Item No.	Report of the Head of Planning, Transportation and Regeneration
Address	LAND OPPOSITE 102 CHURCH ROAD HAYES
Development:	Installation of a 15m high monopole (Application under Part 16 of Schedule 2 to the Town and Country Planning (General Permitted Development) Order 2015 for determination as to whether prior approval is required for siting and appearance)
LBH Ref Nos:	74600/APP/2019/535
Drawing Nos:	Supplementary Information Photographic Aerial Surveys - Site Panoramic Photographs 100 Rev. A 101 Rev. A 200 Rev. A 201 Rev. C 300 Rev. A 301 Rev. D General Background Information for Telecommunications Development Supporting Technical Information - Coverage Plots ICNIRP Declaration Developer's Notice

1. SUMMARY

REFUSAL for the following reasons:

Drawing Title:
PROPOSED SITE PLAN

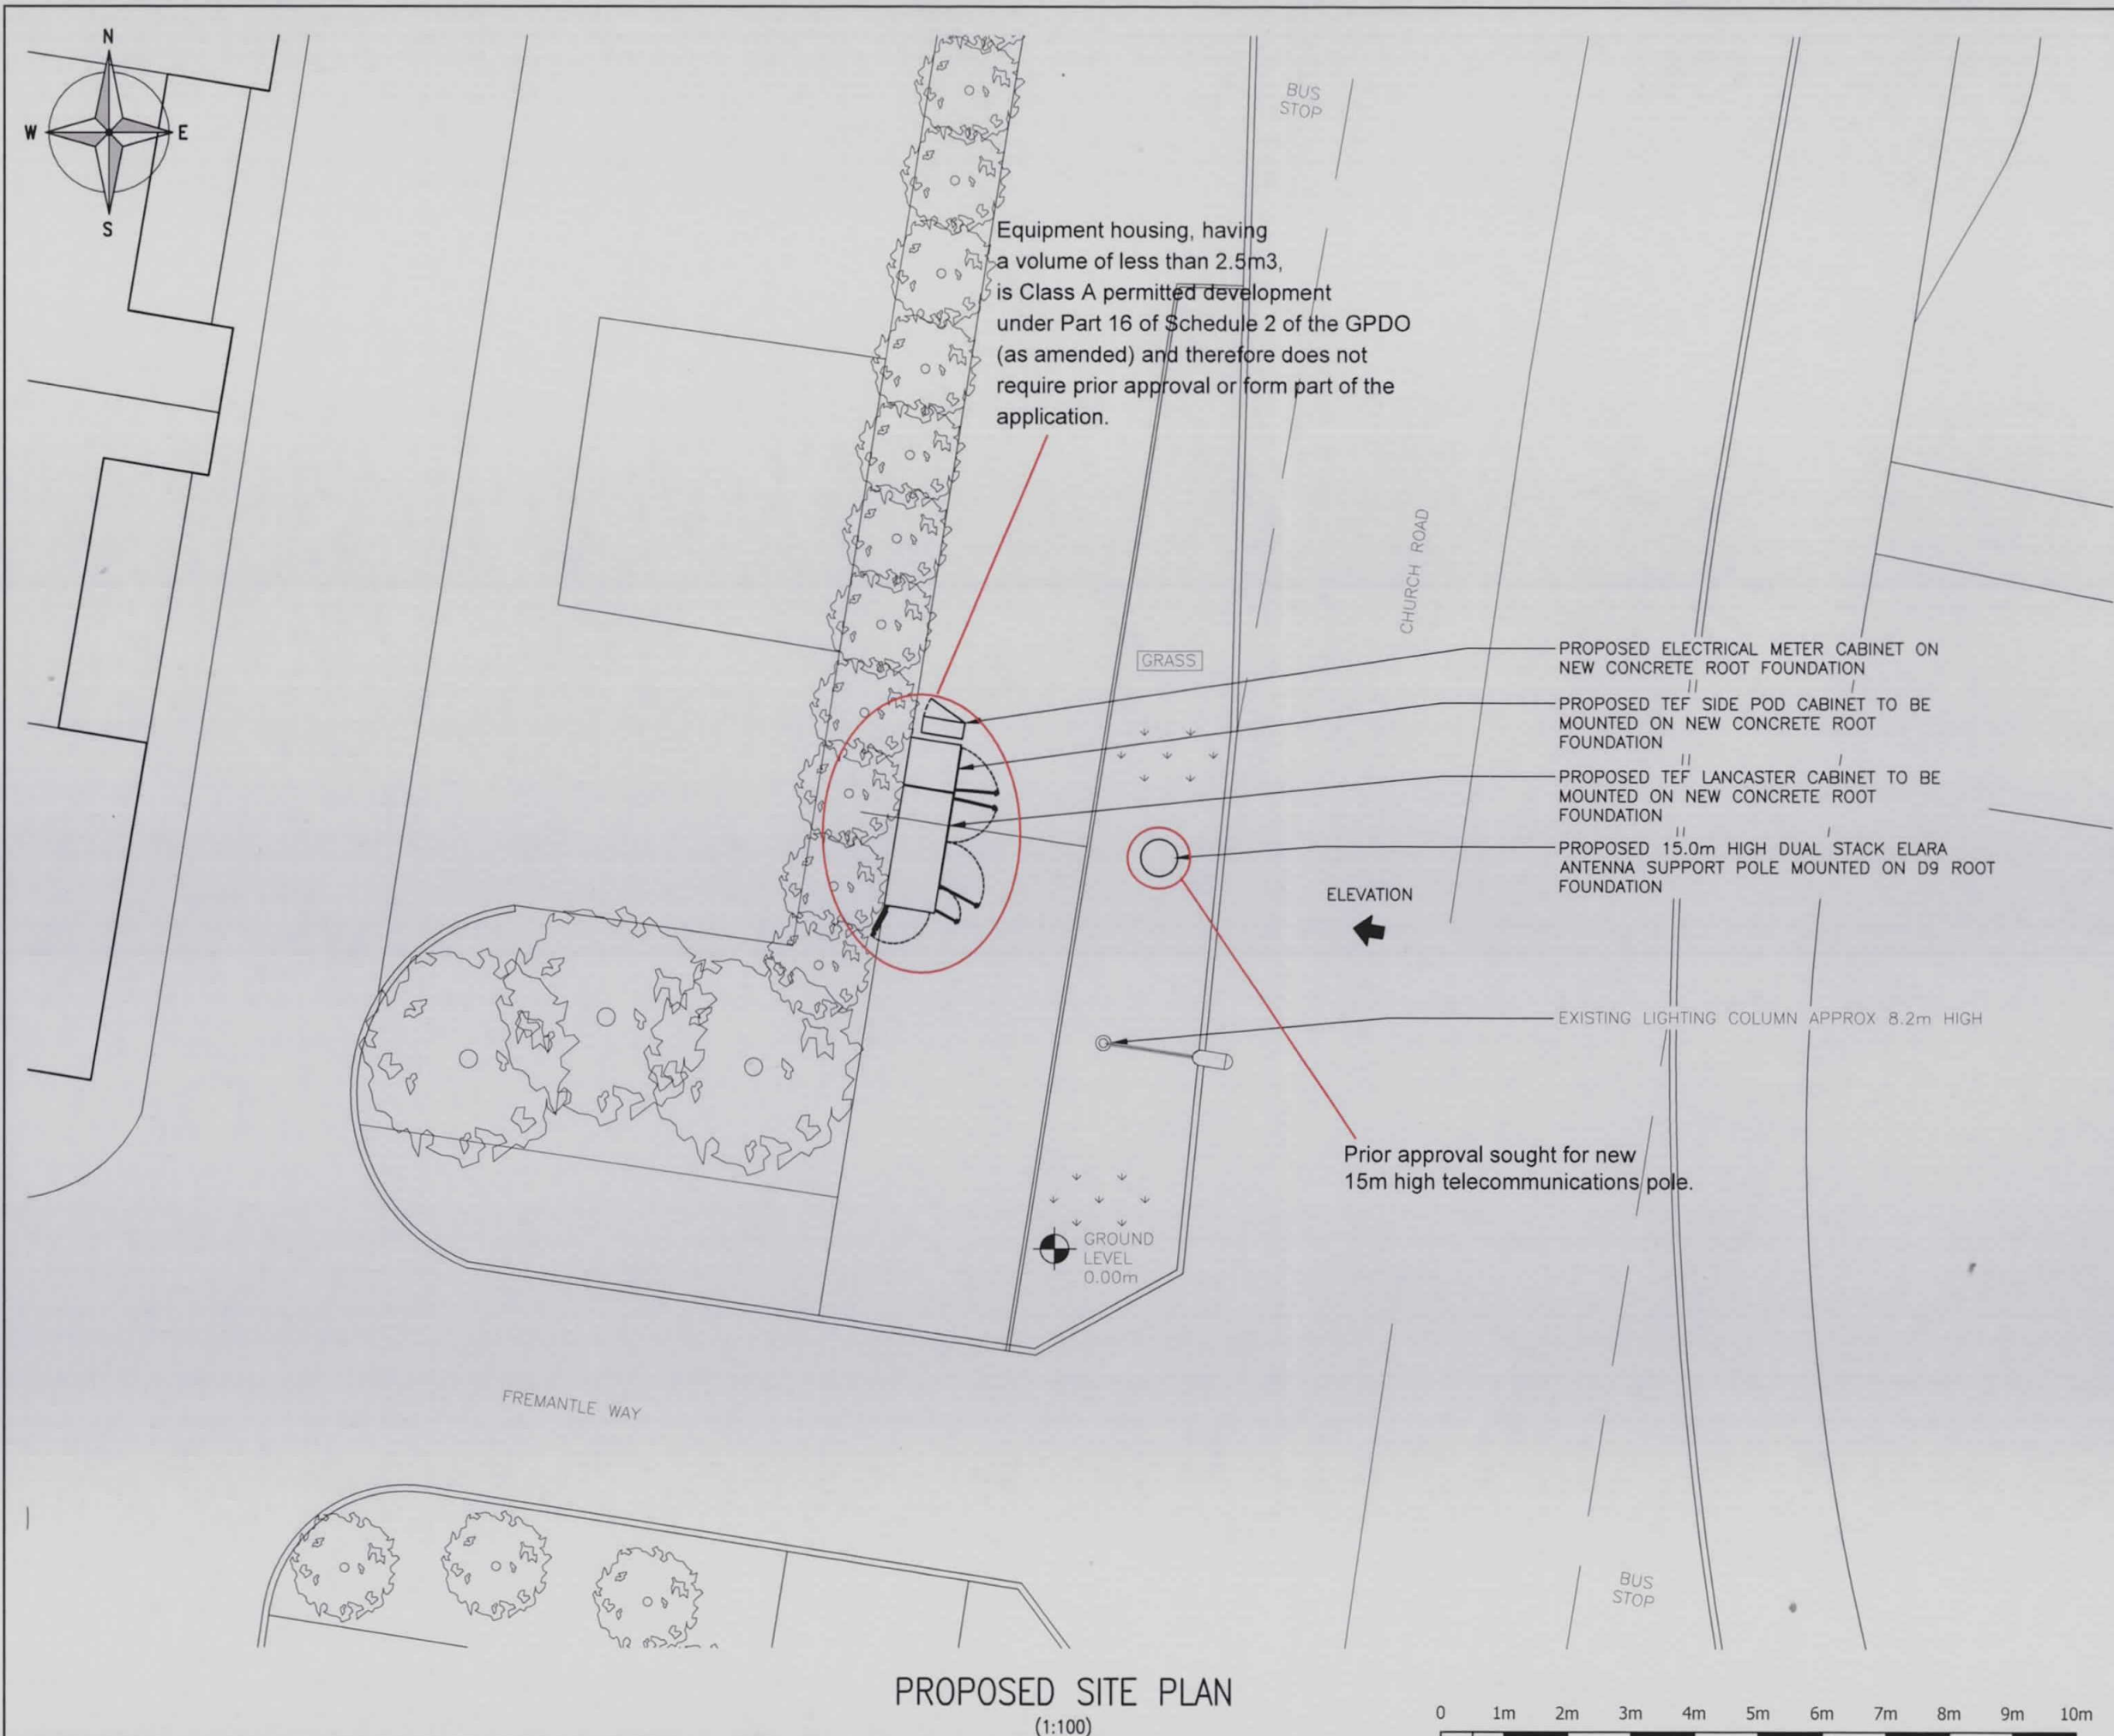
Whilst there is a 2.2m wide section of pavement between the grass verge and the permitted development cabinets, when the cabinet doors are opened for maintenance, this

is reduced to 1.5m.

In order to maintain adequate footpath clearance when the cabinet doors are open for maintenance purposes, there should be a minimum distance of 1.8m between the edge of the grass verge and the cabinet doors when open.

The Council's Highways Engineer has assessed the application. The proposed monopole would not encroach onto the public footpath and highway. The associated equipment cabinets would reduce the width of the footpath from 3m to 2.2m; when the cabinet doors are opened for maintenance, the width of the footpath is further reduced to 1.5m. In order to maintain adequate footpath clearance for pedestrians (including people with pushchairs and wheelchair users) there should be a minimum distance of 1.8m between the edge of the grass verge and the open cabinet doors.

Given the reduction in the width of the footpath and the proximity of the equipment cabinets to the proposed monopole, it is considered that there would be an insufficient amount of footpath clearance for pedestrians along this section of Church Road. As such, it is considered that the proposed telecommunications installation would cause harm to pedestrian safety, contrary to Policy AM7 of the Hillingdon Local Plan: Part Two - Saved UDP Policies (November 2012).
